Ribble Valley Borough Council
Housing & Development Control

Application no: **3/2021/0985**

Address: **84 Whalley Road Clitheroe BB7 1EE**

The Local Highway Authority have viewed the plans and highway related documents and have the following comments to make:

Drawing Title
Proposed Plans, Elevation and Section

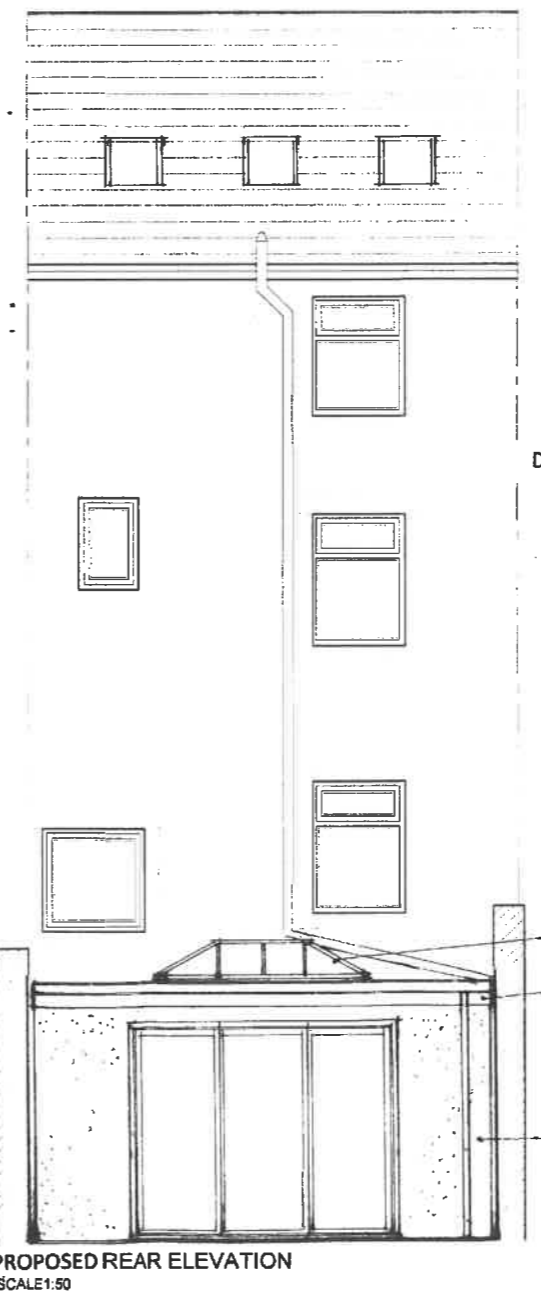
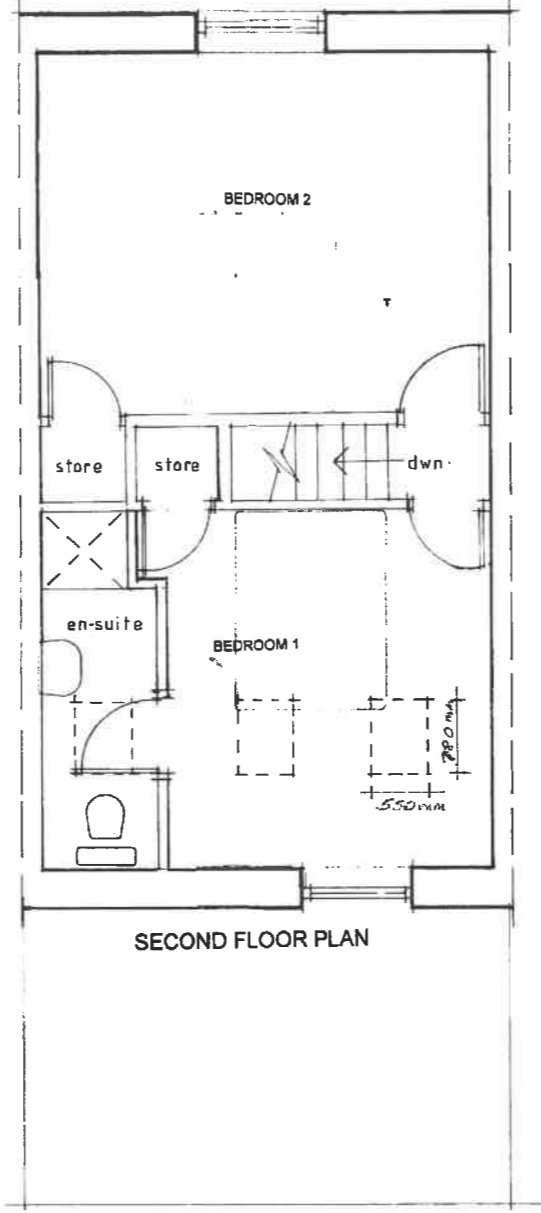
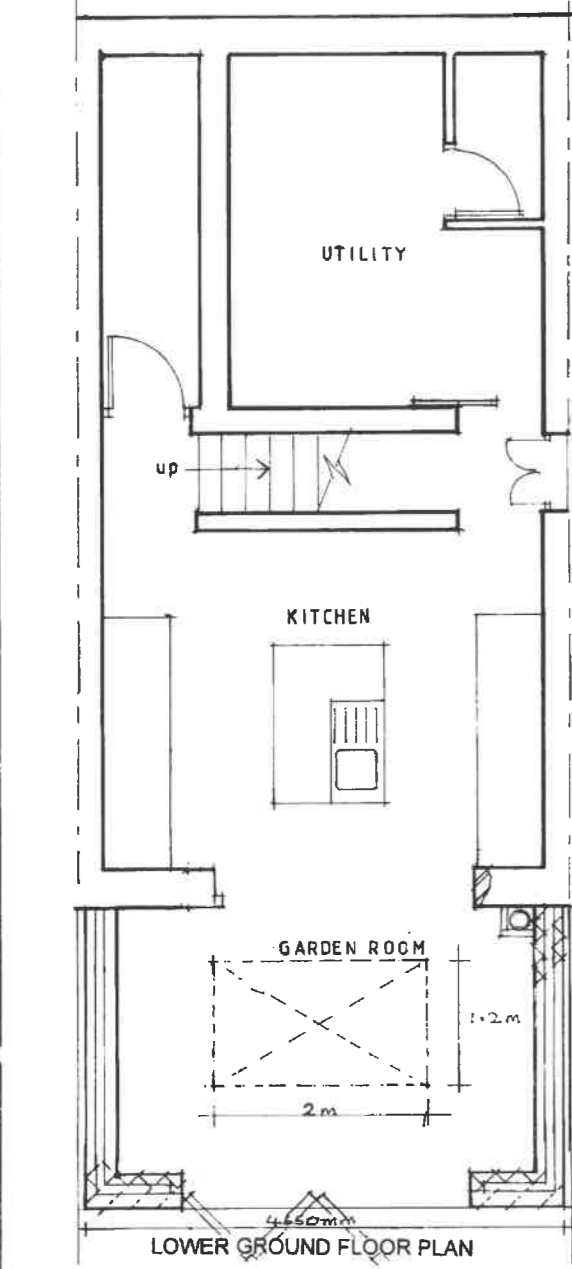
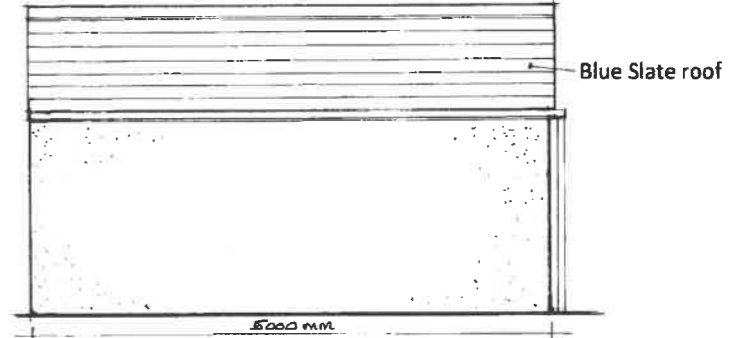
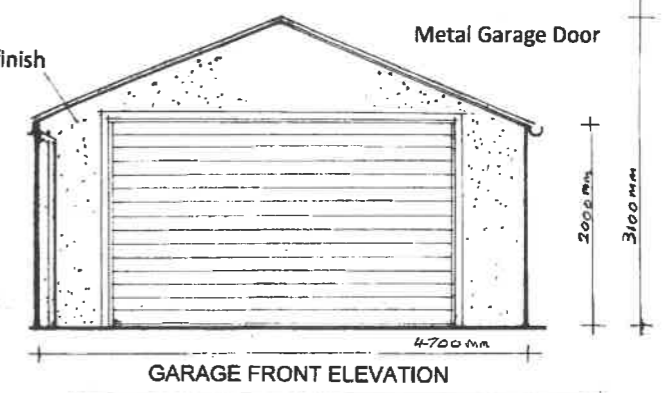
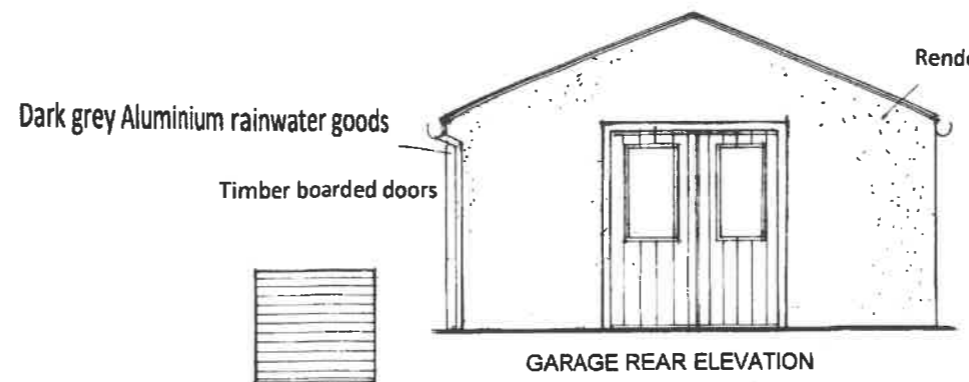
The LHA have reviewed the SPA drawing number 6410-02 titled "Proposed Plans, Elevation and Section" and understands that the dwelling will remain a 2-bed property.

The LHA remind the Applicant for the site to comply with the parking standards as defined in the Joint Lancashire Structure Plan, the LHA require 2 car parking spaces to be provided at the dwelling but will accept a minimum of one space in this case.

However, the LHA have further reviewed the drawing and understands that the proposed replacement garage will have the dimensions of 4.7m x 5m. The dimensions of the garage do not comply with the LHAs guidance which requires a garage providing one car parking space to have the minimum dimensions of 6m x 3m. Therefore, the LHA either require a revised plan showing that the single garage complies with the LHAs guidance or the Applicant can provide a plan of the existing driveway showing that the length exceeds 4.8m, which is the minimum requirement for the length of a driveway providing one car parking space.
